Recommendation Report for Planning Permission for Works or Extension to a Dwelling

REF NO: AW/272/21/HH

LOCATION: 73 Marlborough Court
Bognor Regis
PO21 5QJ

PROPOSAL: Single storey rear extension and conversion of garage to kitchen

Drawing No.
3 (32) 01

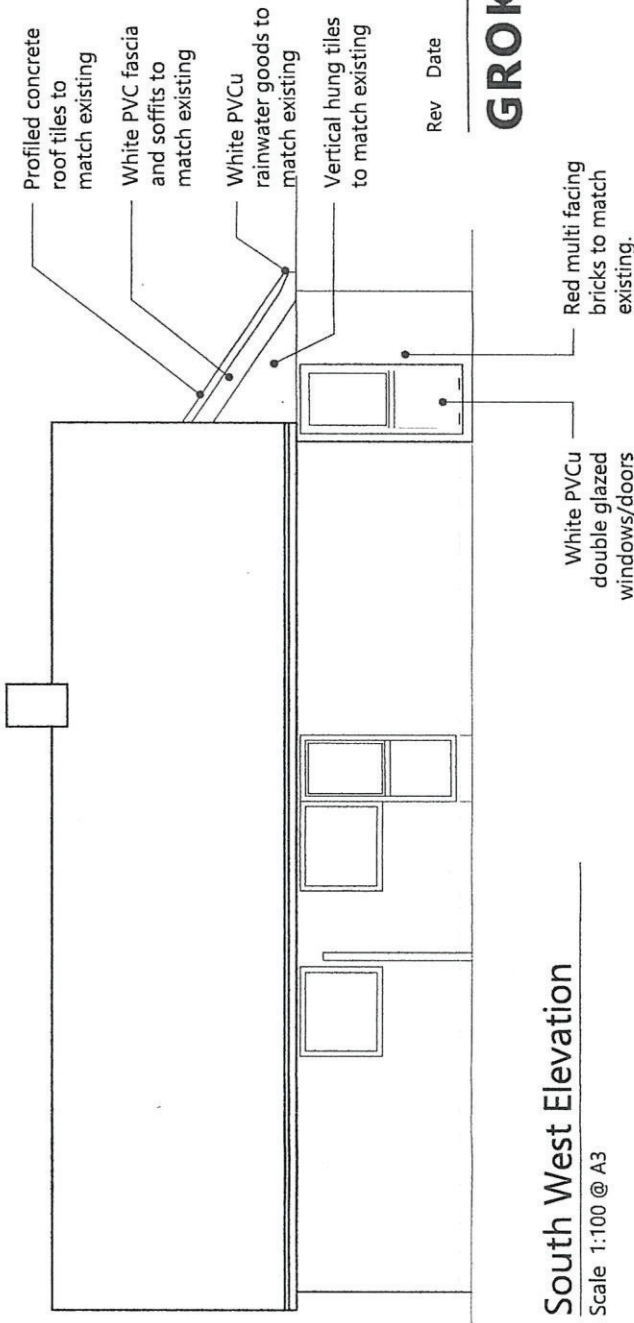
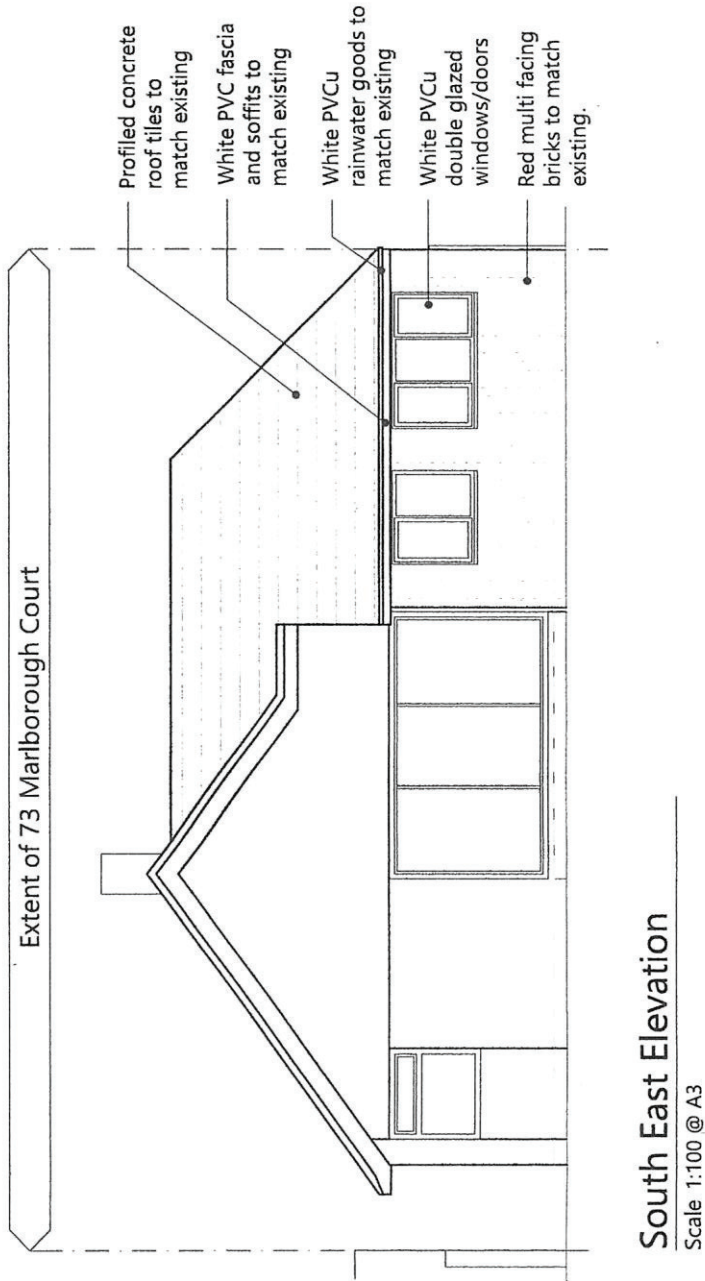
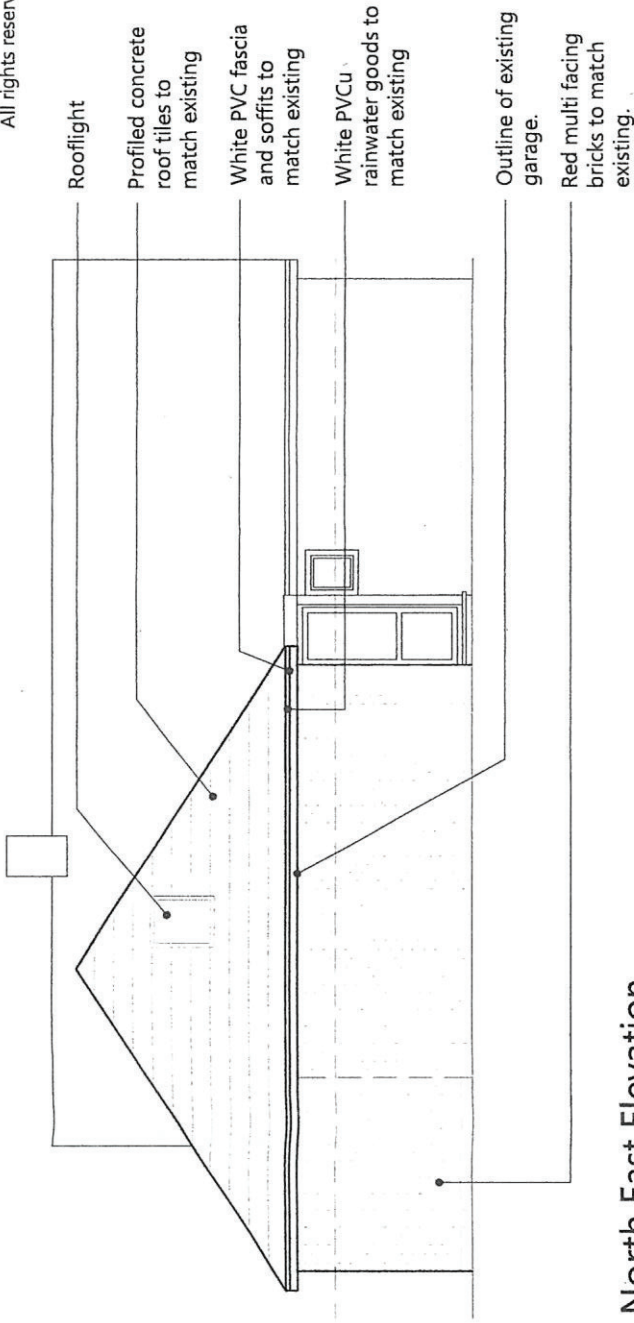
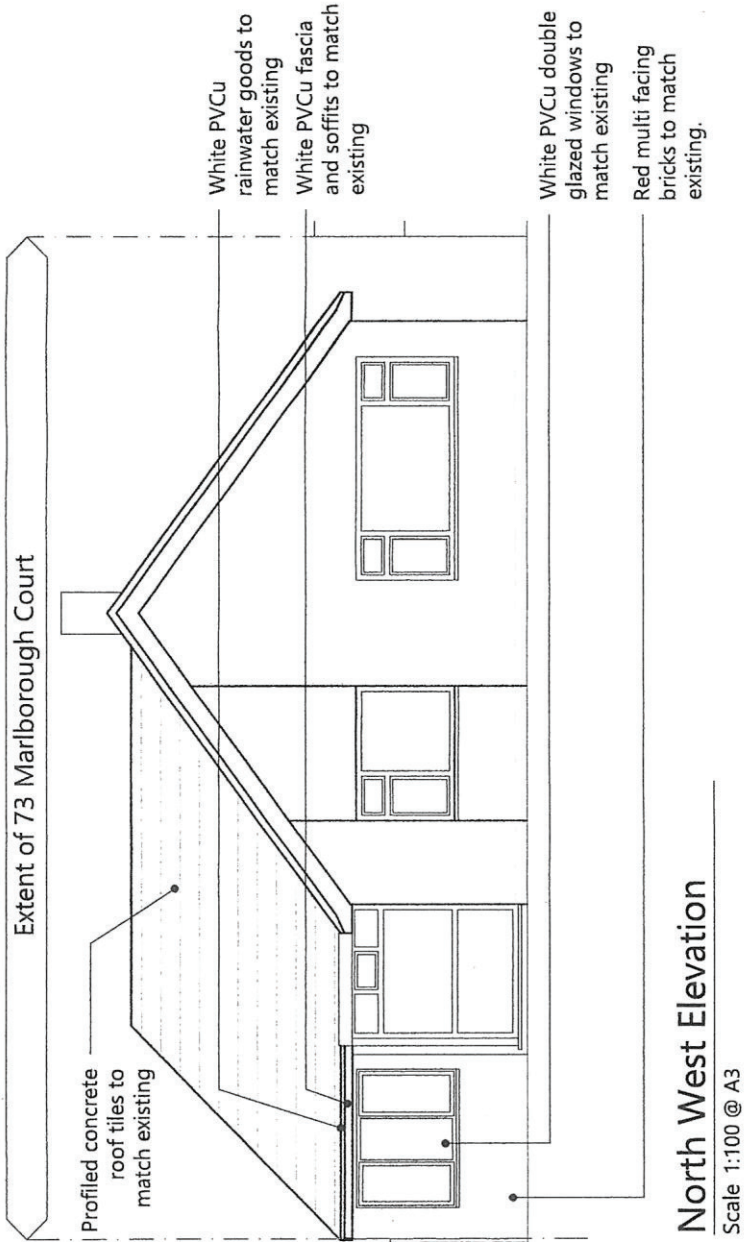
The proposed single storey rear extension will be sited to the rear (south east) corner of dwelling and its new pitched roof will also run along the side (north east) of the property over the existing garage. As a result the proposed pitched roof of extension will be higher than existing garage roof so will be visible from street scene.

Whilst the new pitched roof is visible from street scene, the existing garage is set back from front boundary by around 17.26m so the impact on the street scene is reduced so does not adversely impact street scene or character of surrounding area. Also the pitched roof design seems to visually integrate with main dwelling roof and is visually subservient so complies with policy D DM1 and D DM4 of the Arun Local Plan.

The conversion of garage to kitchen will contain one new window (3 window panes) to front (north west) and one new rooflight to side (north east) roof plane.

The single storey rear extension has a length of approximately 2.66m running along side (north east) elevation, a width of approximately 4.715m and a depth of 2.00m jutting out from rear (south east) elevation. The height to top of pitched roof is approximately 5.24m. There will be two new sets of windows to rear (south east) elevation and one new single door to side (south west) elevation.

Due to two new sets of windows to rear (south east) elevation there is increased risk to overlooking to neighbouring property to north east however due to siting of rear extension beyond building line to north east there is no adverse impact to overlooking into neighbouring property number 71 to north east so is acceptable.

The one new single door to rear side (south west) elevation will not cause increased overlooking effects to neighbouring property number 75 due to extension being at single storey, existing boundary fence to south west boundary and a gap of around 8.48m remaining to boundary so is acceptable.

Roof Plan

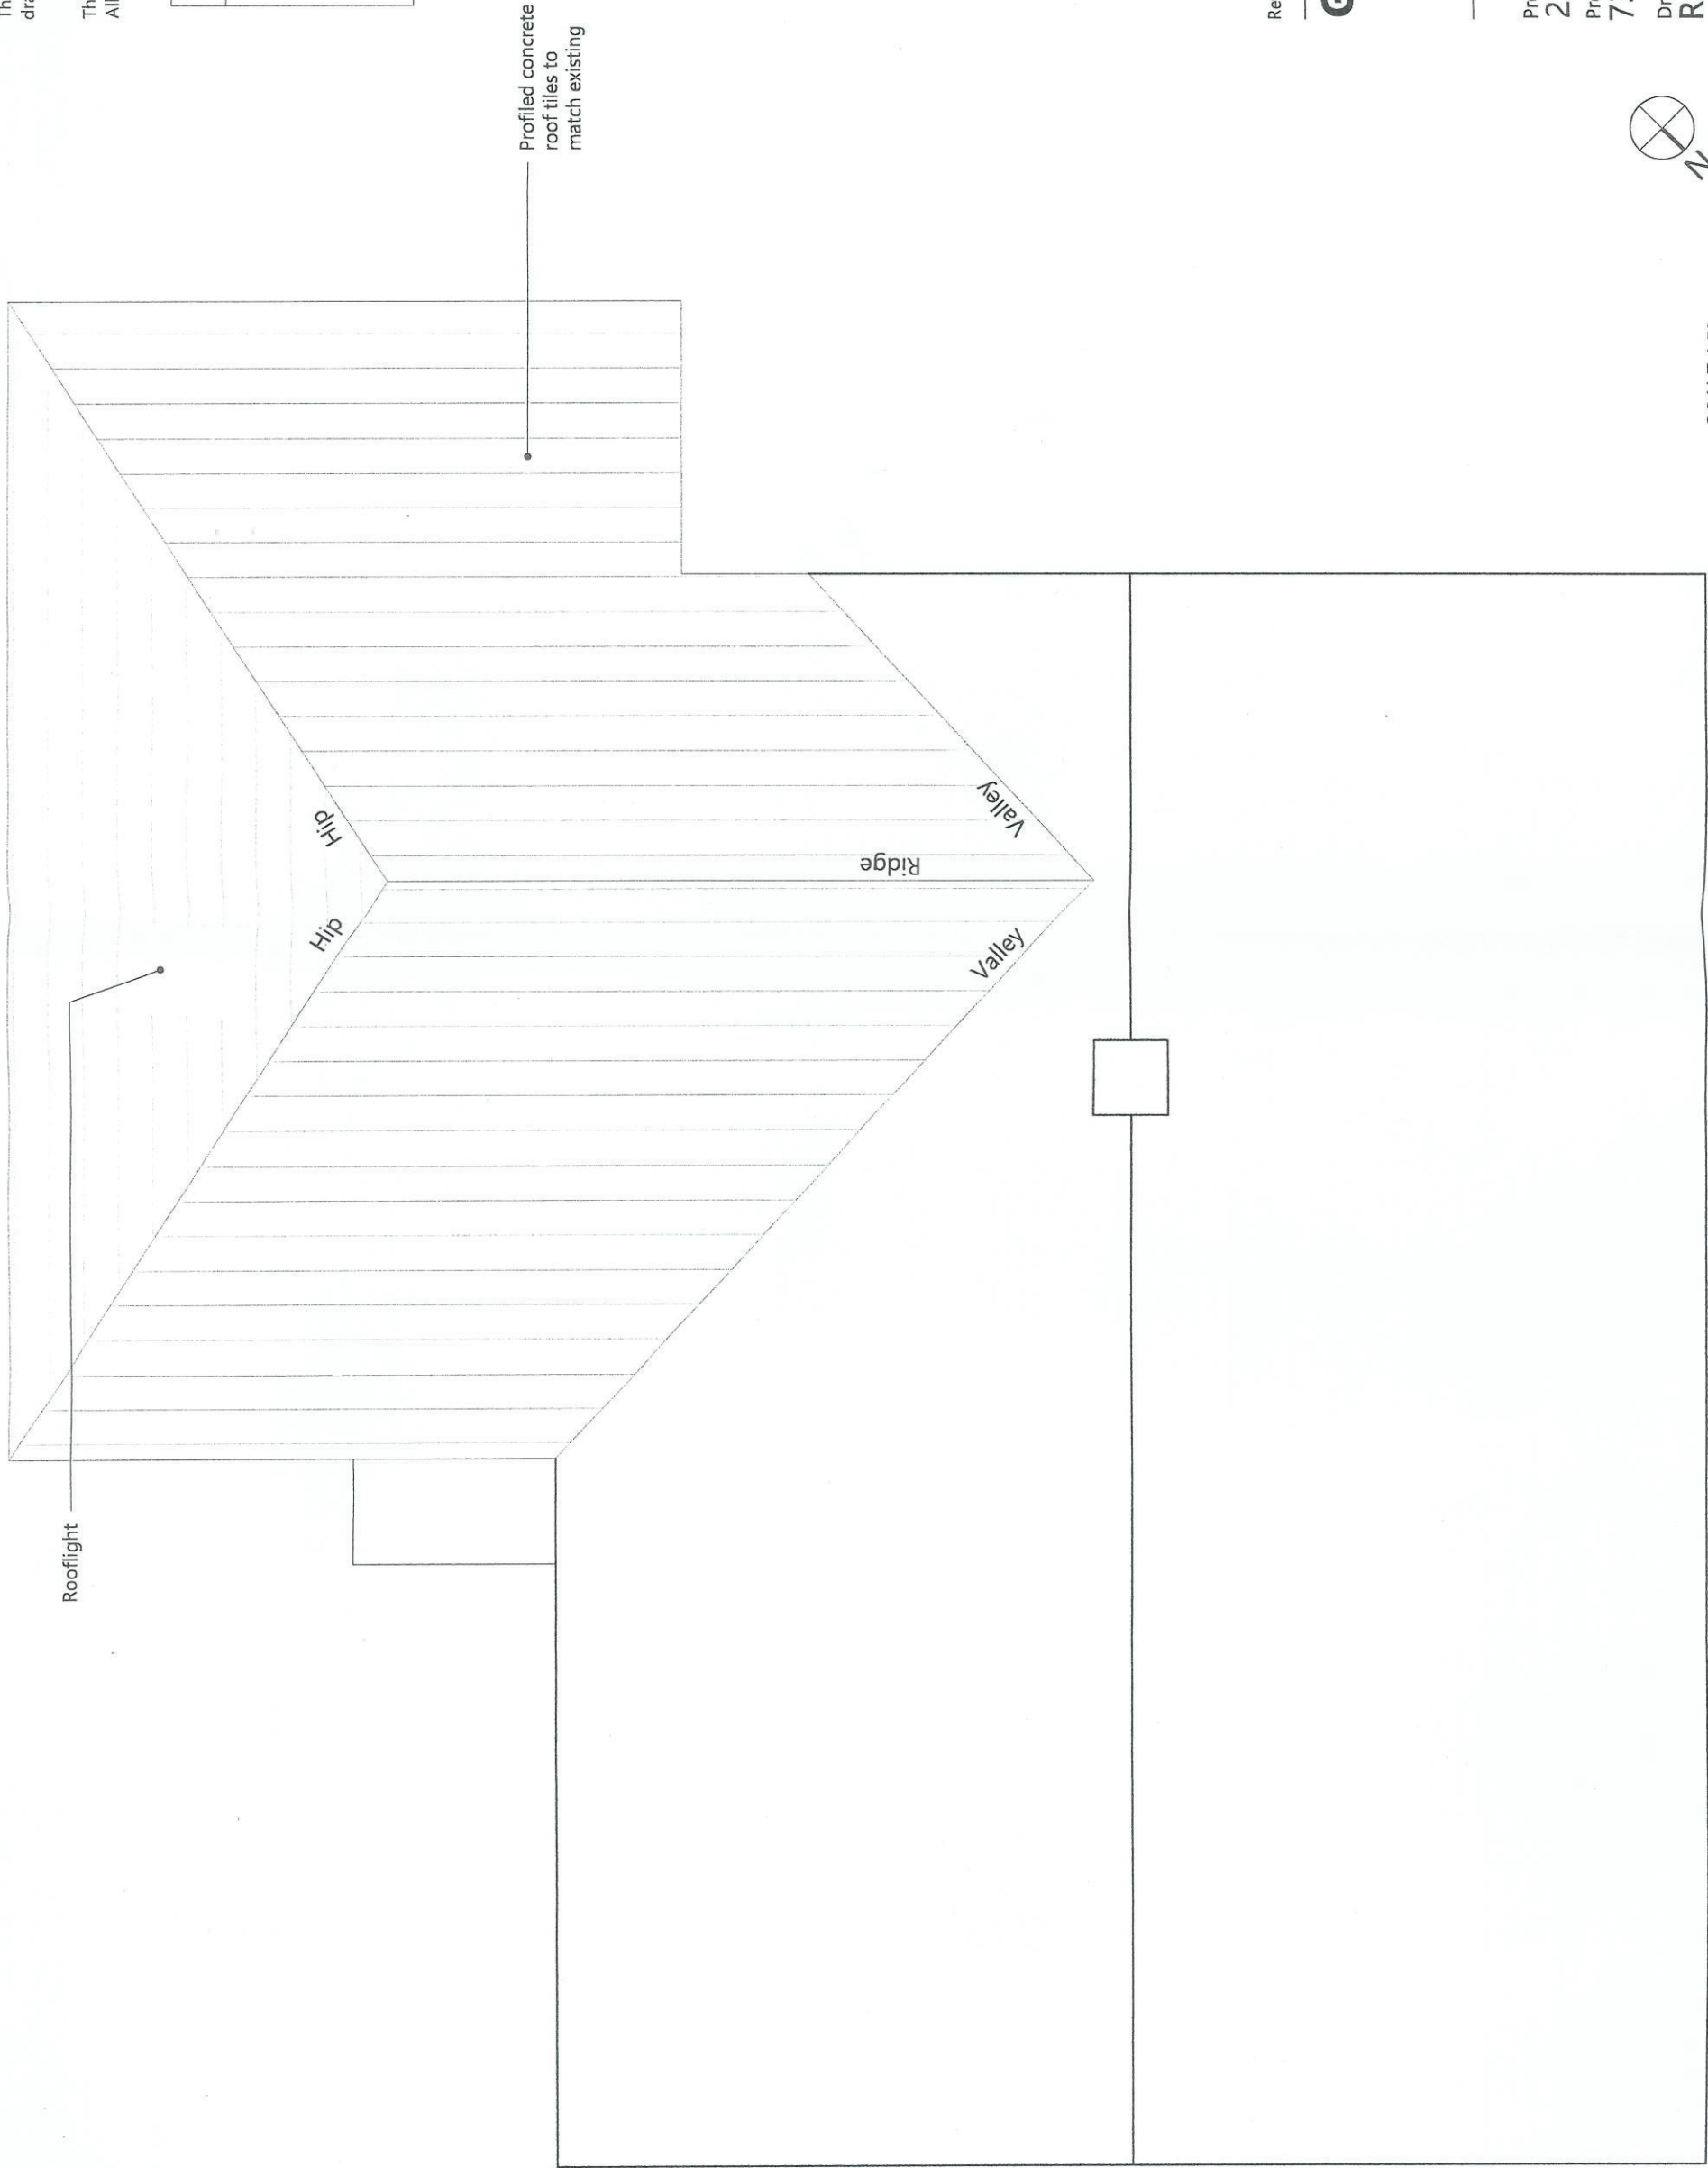
The existing garage will have only internal alterations so the dimensions will not alter externally except the roof of the existing garage will be converted into a pitched roof joining to the new extension to rear.

The new roof light to north east roof plane is at high level so does not cause adverse harm to overlooking to north east.
